PROJECT TITLE: Sawmill Townhouses ZONE ATLAS/DRNG. FILE #: J-13 /D26

RE: DRAINAGE PLAN FOR SAWMILL TOWNHOUSE (J13-D26) RECEIVED SEPTEMBER 5, 1985

RE: DRAINAGE PLAN FOR SAWMILL TOWNHOUSE (J13-D26) RECEIVED JULY 26,
1985.

DRAINAGE REPORT
FOR
SAWMILL TOWNHOUSES

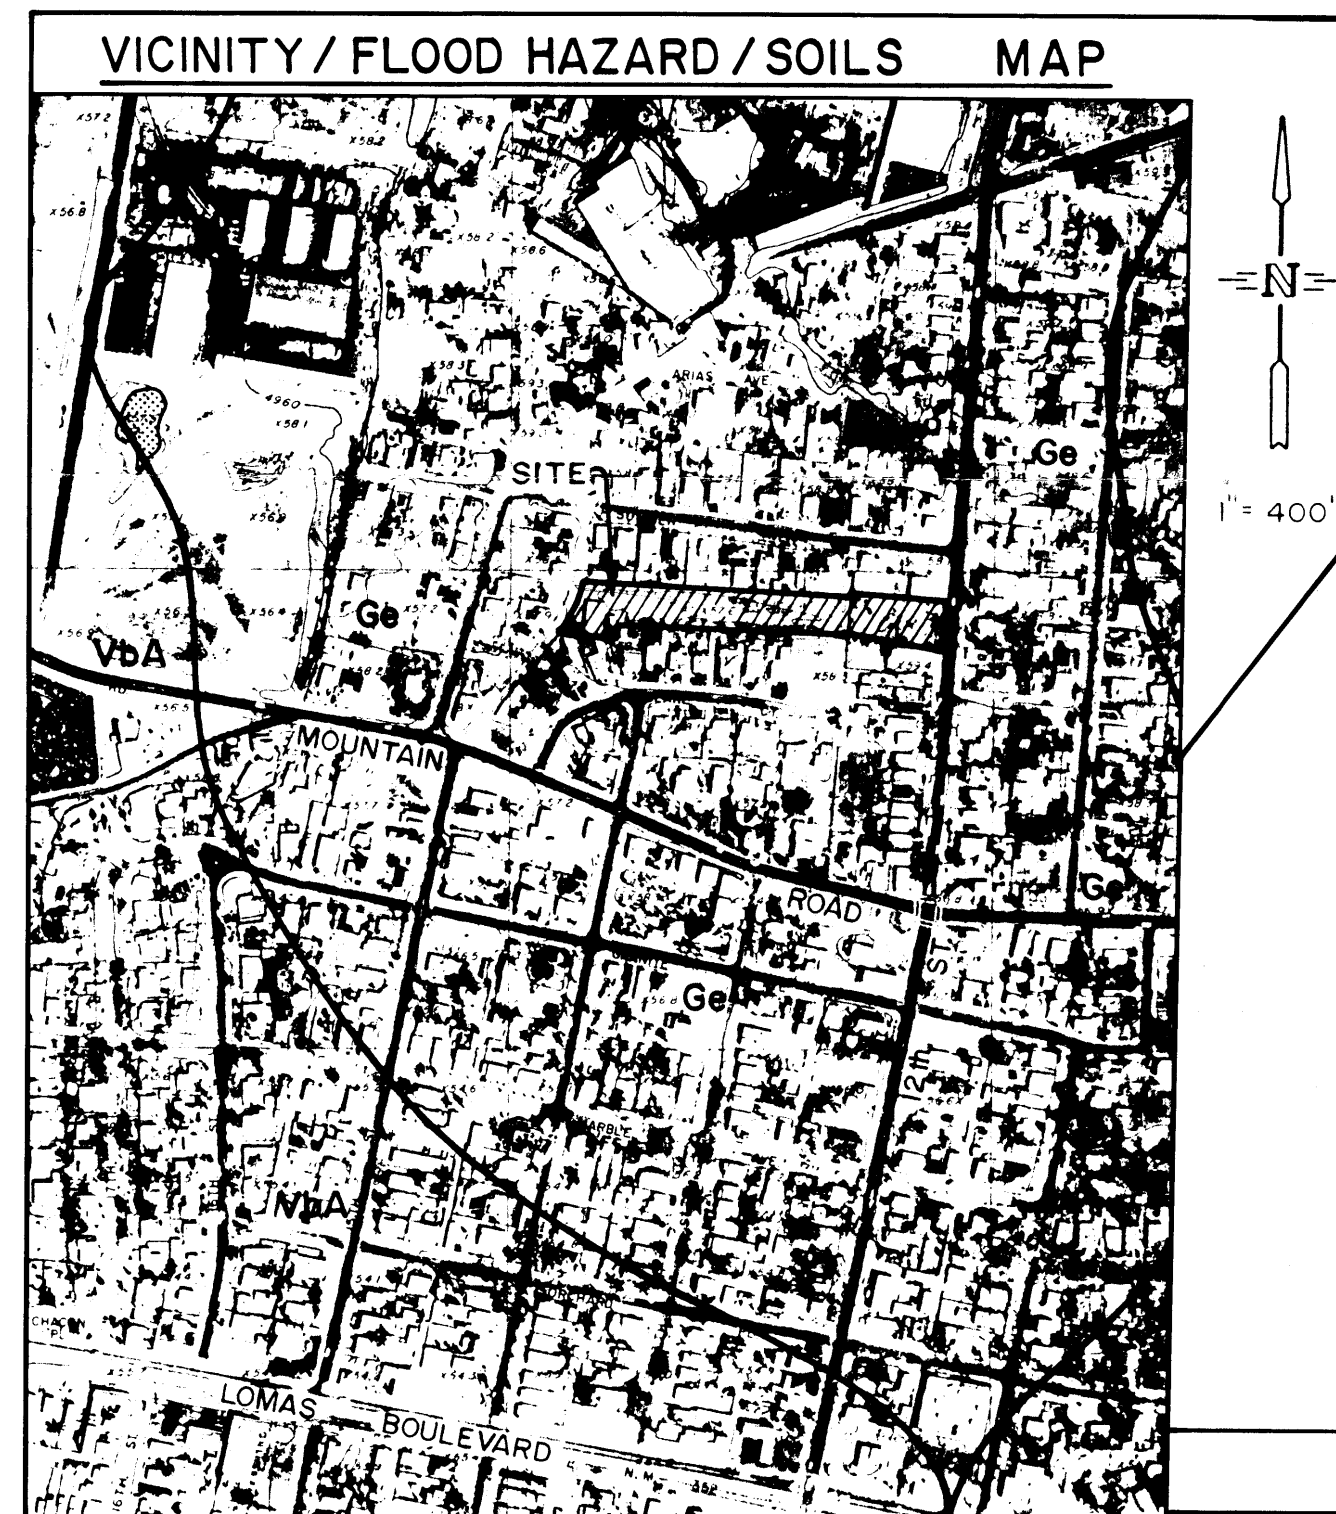
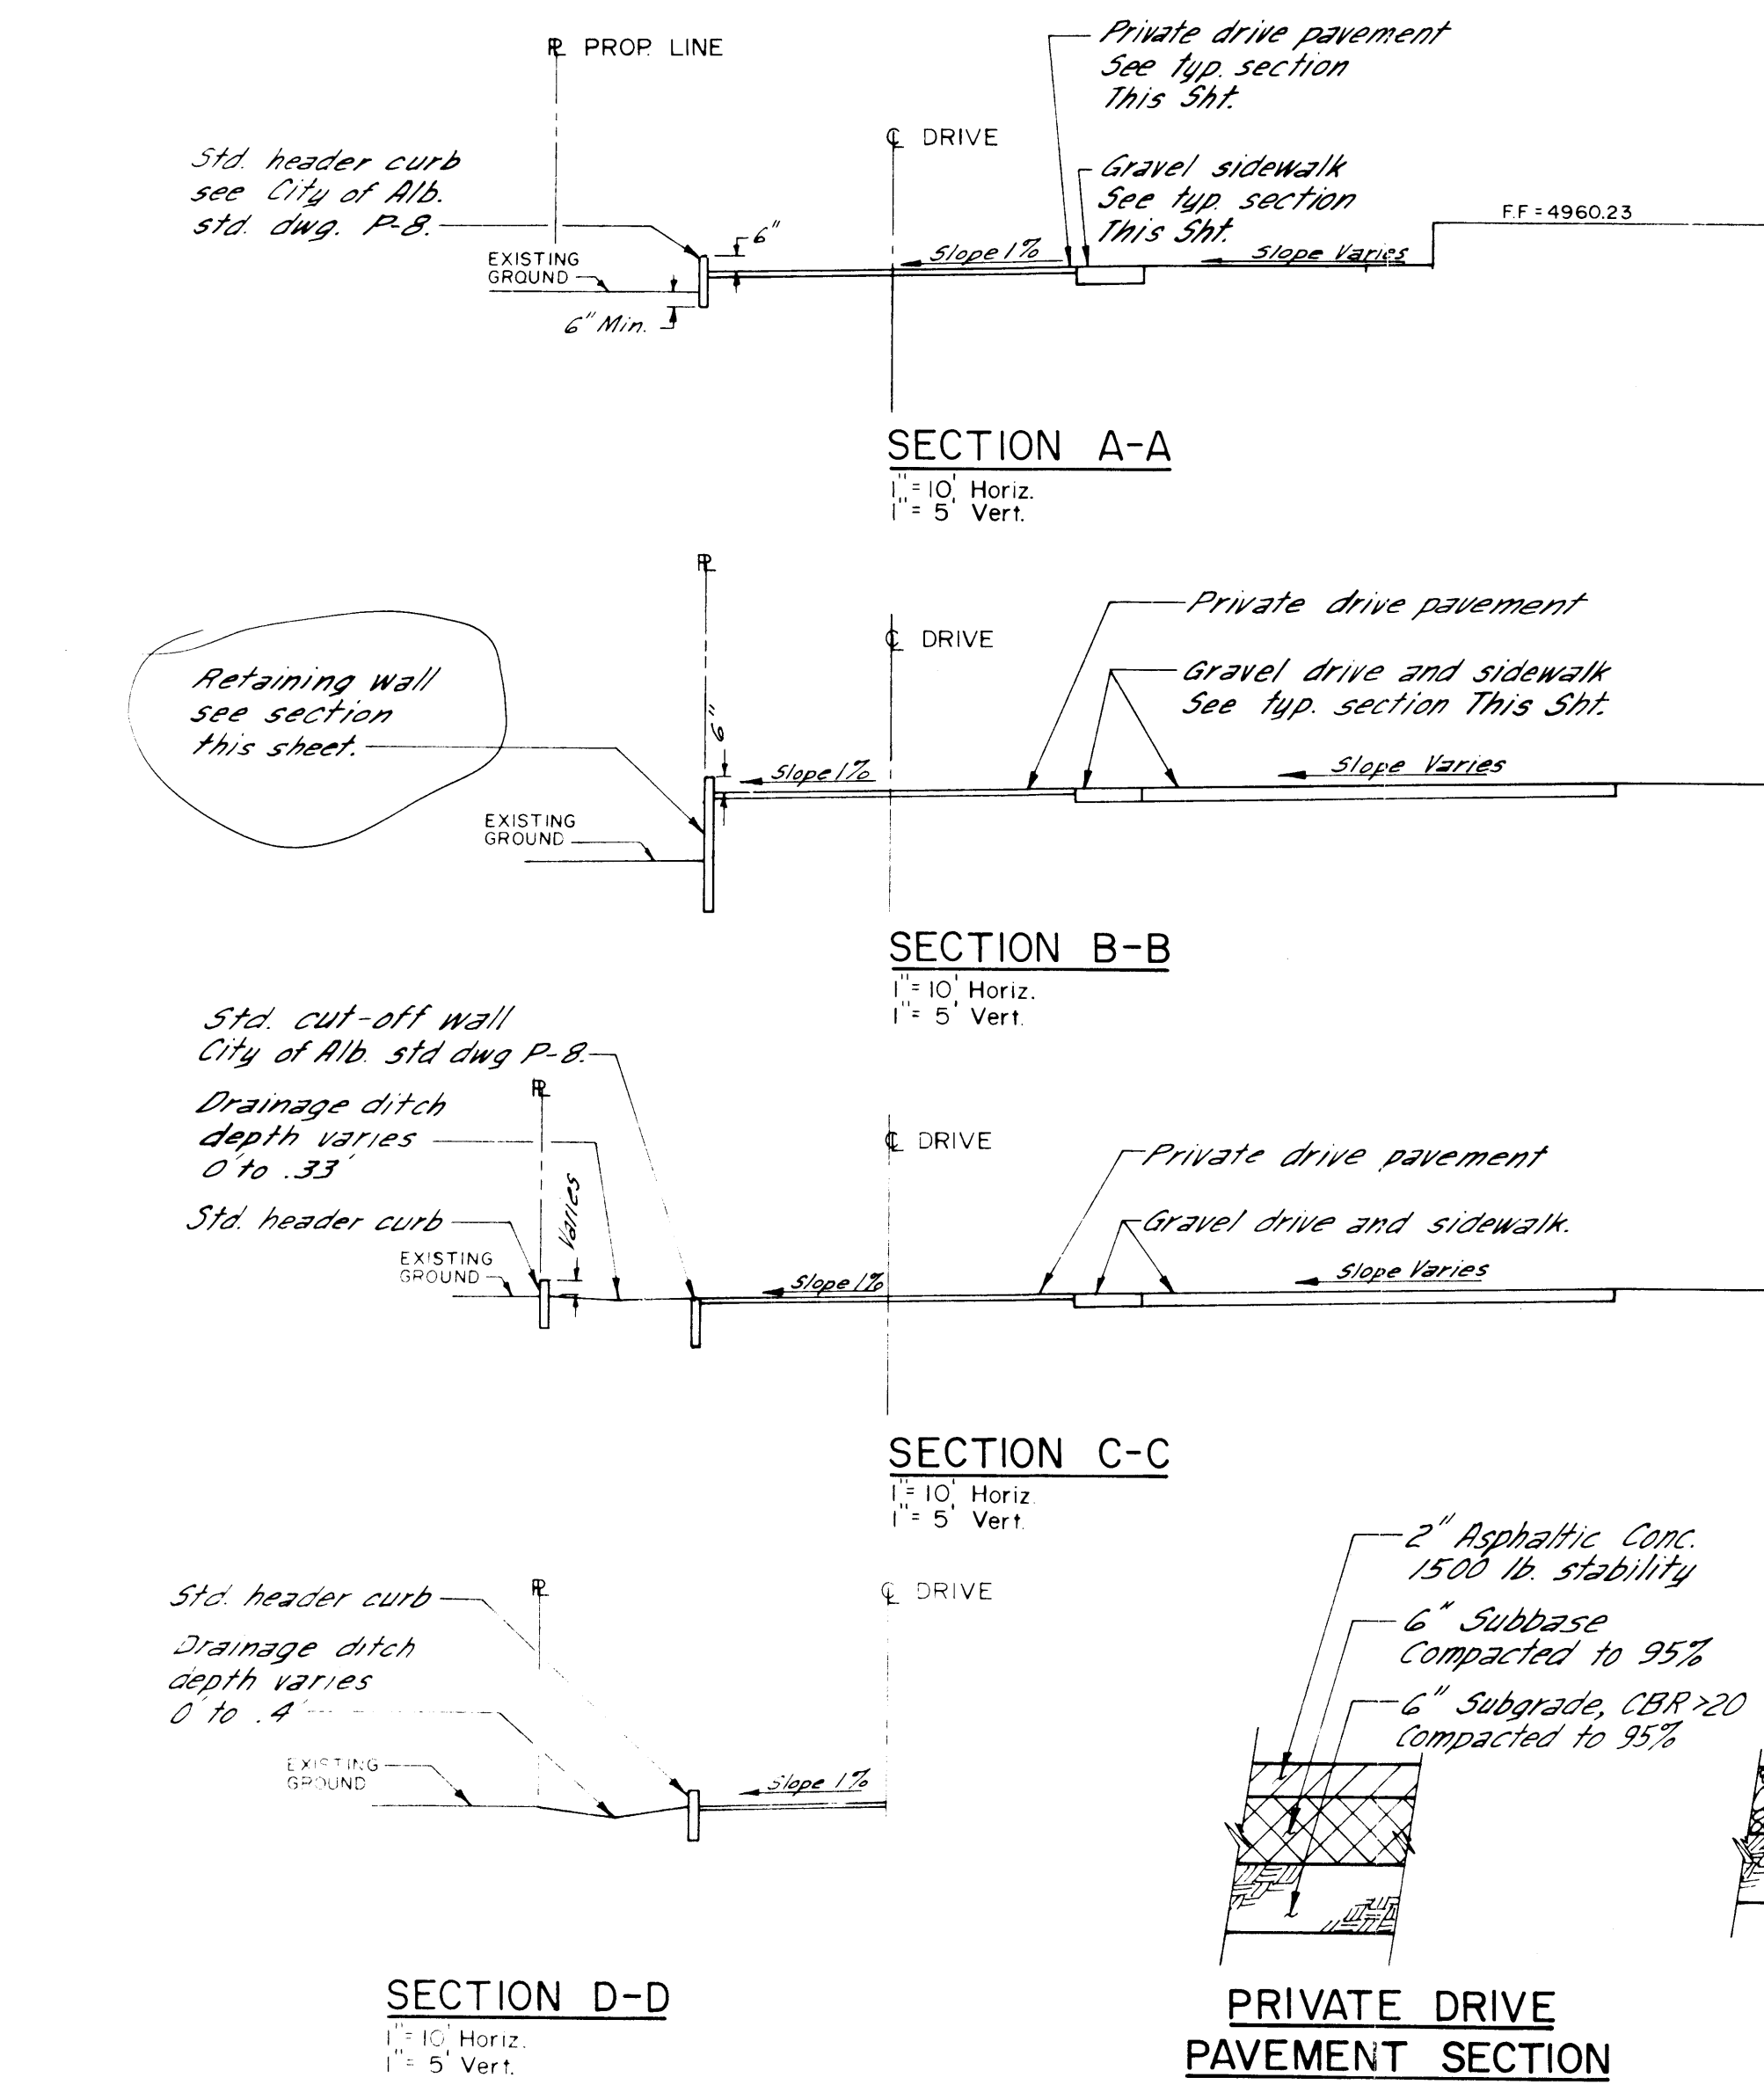
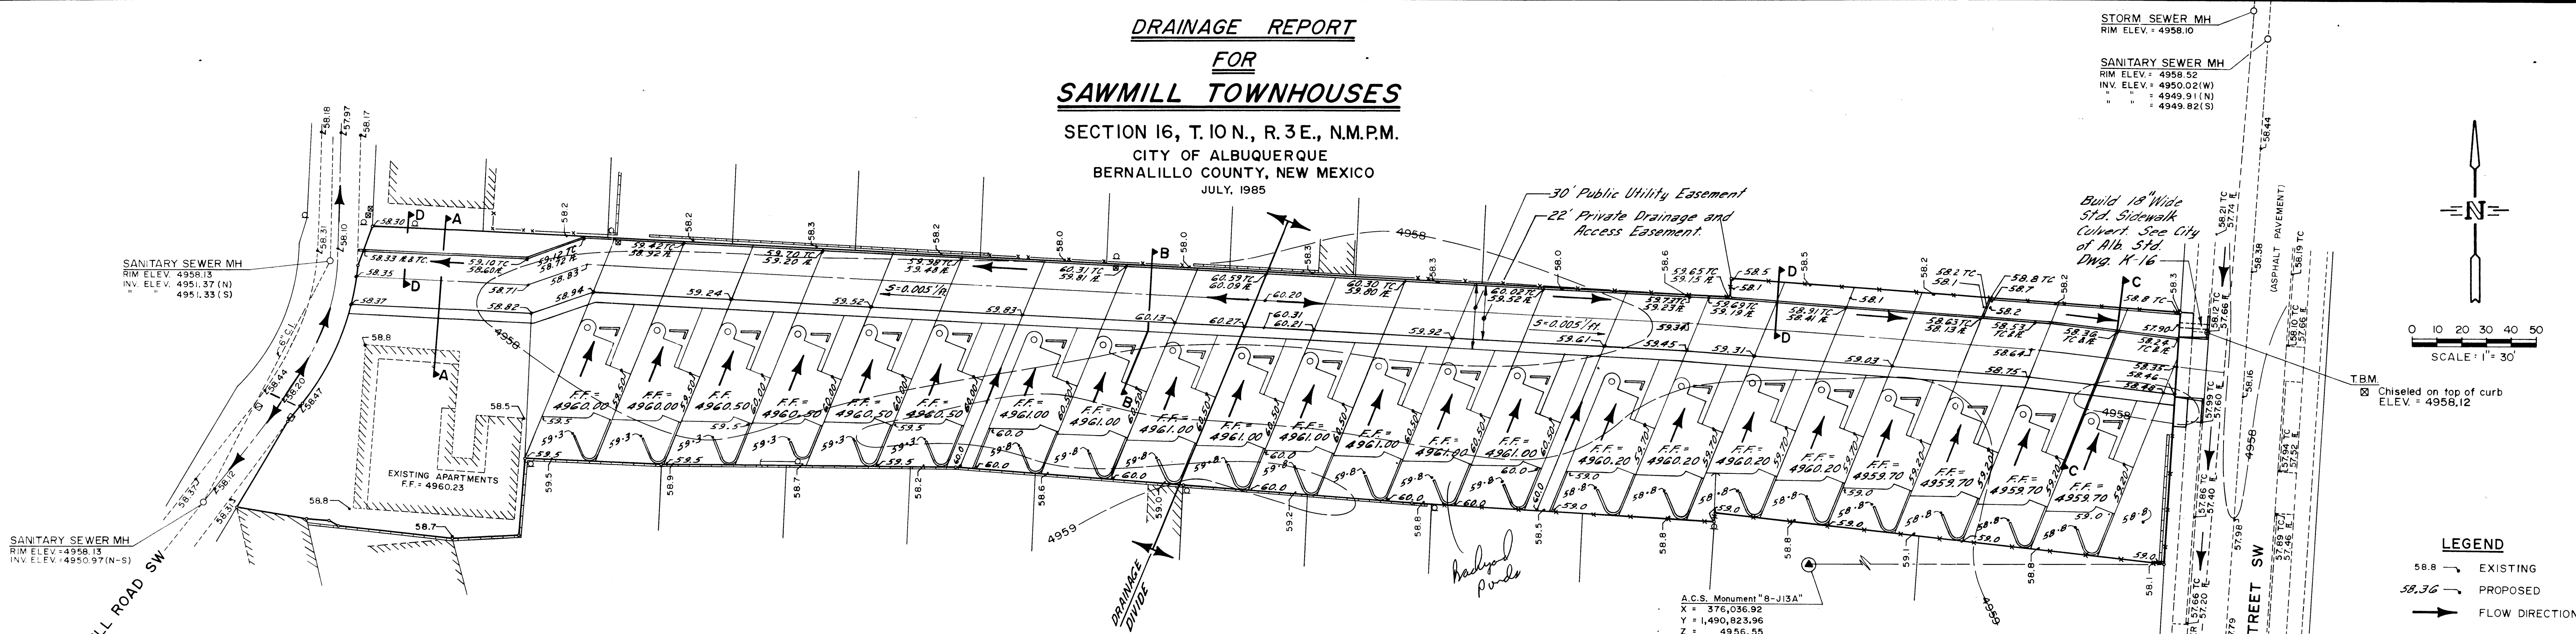
1. Require city approved street grades for Sawmill Road.
2. Section B-B indicates retaining walls, however, the plan view does not show the extent of the retaining wall.
3. Please address the impacts of the site run-off to immediate adjoining properties.
4. A review of a 1976 topographic map of the area shows that flows from Sawmill Rd. may pond on Summer Ave. Please show with elevations how flows will be conveyed from Sawmill Road to Mountain Rd.

1. Sawmill was built by the City as "Community Development Program CD-4A".
2. Until we have a final decision from the Zoning Hearing Examiner, we cannot precisely define the exact length of retaining wall required. I can say that the maximum length required would be 390 feet and the minimum would be 240 feet. The maximum vertical amount retained will be 2.0 feet.

3. Based upon close examination of the 1"=200' topo map and field examination of the situation, it appears that runoff flowing north on Sawmill towards Summer will trend westward on Summer to 15th Street. 15th Street flows southward towards Mountain Road where there is an existing storm drain system. Also from field examination, it appears that there is so little grade outside of the streets that it is safe to say that the only runoff results from rainfall that falls in the streets. Sheet J-13 of the Albuquerque Master Drainage Plan confirms this analysis in that no flooding problems are indicated within a reasonable distance of this site.
